**Application: SSI 7485**

I write regarding the proposed modification to M4-M5 Link, Mod 2 The Crescent overpass and changes to pedestrian infrastructure in North Annandale, Rozelle and Rozelle Bay Foreshore area.

Figure 4-2 Pedestrian and cyclist bridge infrastructure options

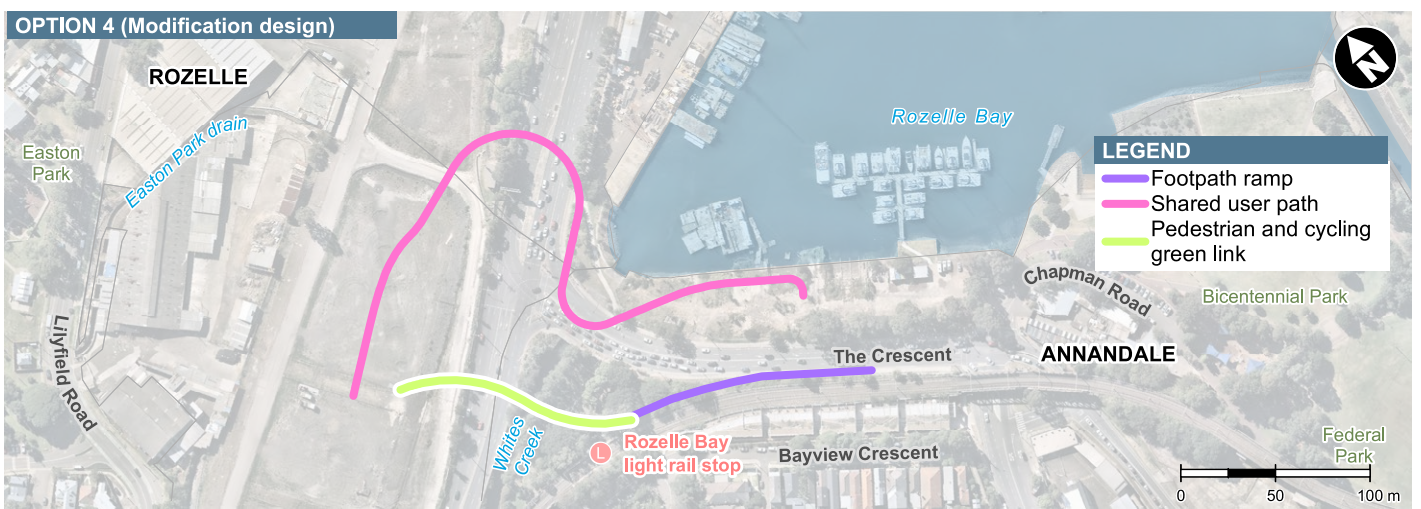
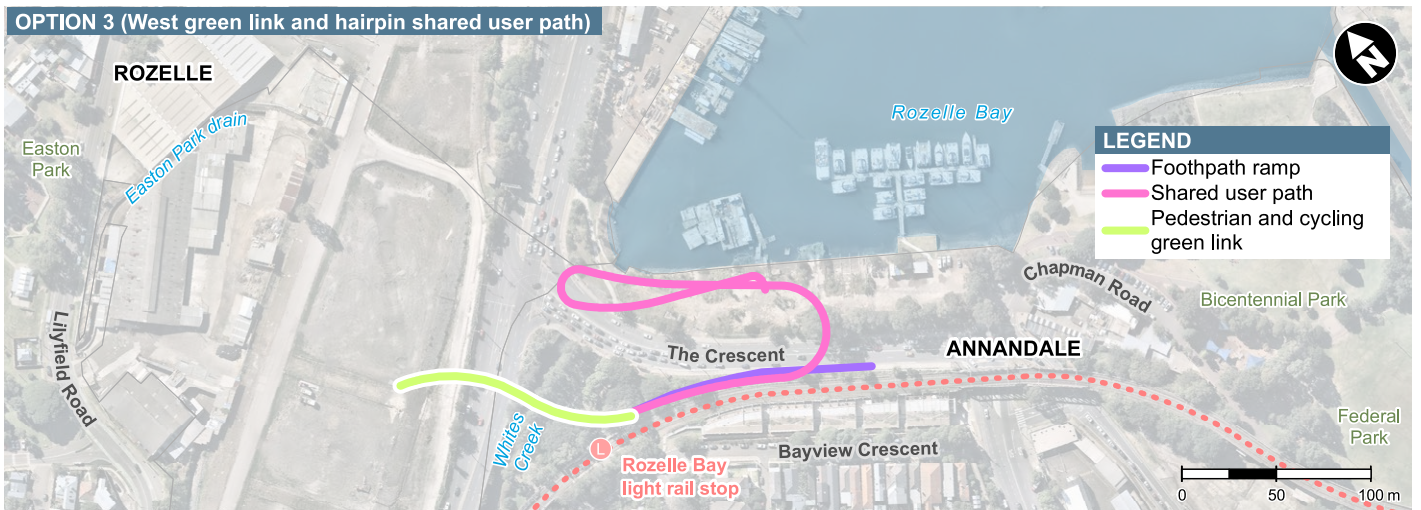
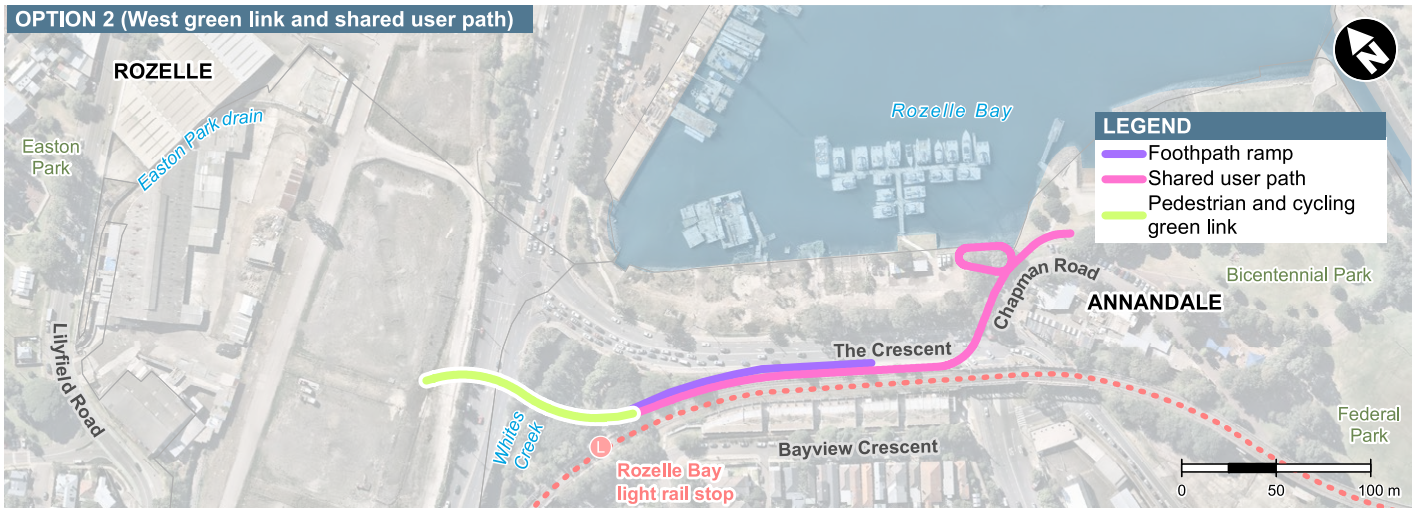
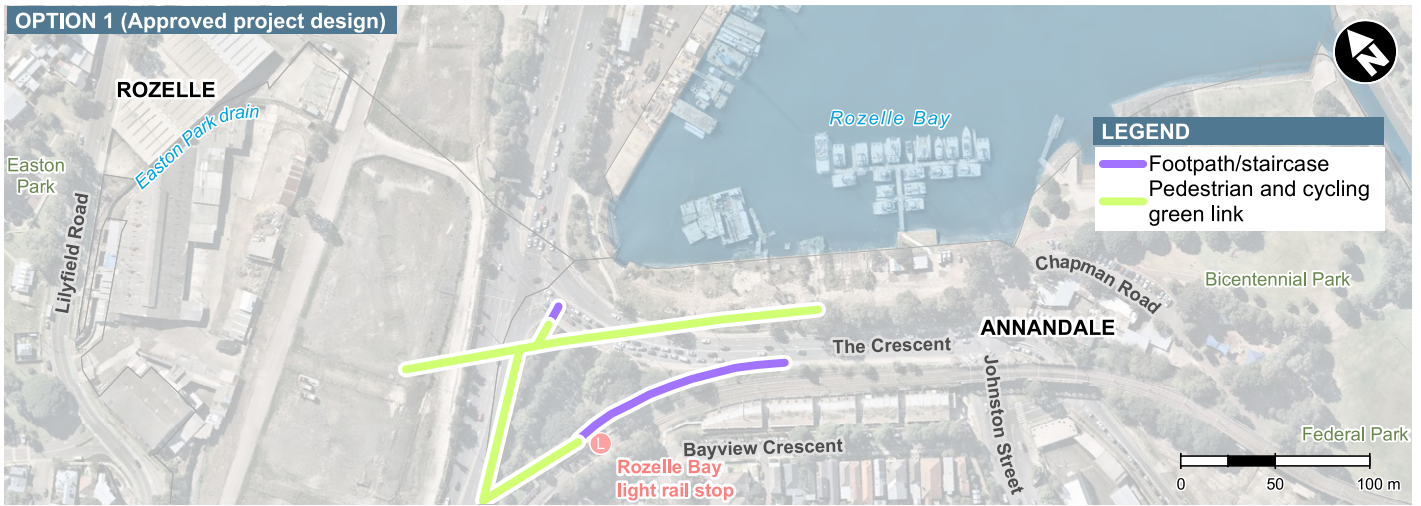
I request RMS work with the community to explore alternate design options to the proposed new car overpass design and the changed pedestrian and cyclist links. I am seeking the reinstatement of the safe, direct access from the approved EIS GreenLink to create a continuous green open space connection from the Rozelle Rail yards and Annandale to the foreshore. The GreenLink was more than just a walk way - it put people central to the design, maximising safety, and providing much needed accessible open space for the community now and into the future Bays Precinct design.

- The significantly reduced safety and increased risk for pedestrians and cyclists with removed access over The Crescent to Bicentennial Park and the increased traffic along Johnson Street.
- Being required to cross five sets of pedestrian lights at The Crescent as my option to reach the foreshore from Annandale or from Rozelle Bay light rail stop.
- Removal of direct active links to the foreshore, cutting the community off from the area and the proposed revitalisation of the entire Bays Precinct, including linking the Light Rail and Bus stops to a Ferry wharf and Metro station.
- Urban and landscape design that is being built before a finalised Masterplan for the area.
- Traffic changes that limit movements around the suburb and create further congestion in the local streets of Annandale, Forest Lodge, Glebe, Lilyfield and Rozelle with no planning to deal with these.

- Reinstate the GreenLink connecting communities and green open space from Rozelle to Bicentennial Park
- Relocate and design pedestrian and cyclist connections that are continuous, safe and direct.
- Design the modification infrastructure and active links in response to the character of the suburbs, the location of the foreshore and its potential future development.
- Provide pedestrian and cyclist paths that maximise people safety and do not force them onto busier streets, unsafe concrete plazas and caged walkways.
- Integrate active and direct connections to all active transport – including the future Metro West and Foreshore Ferry Wharf
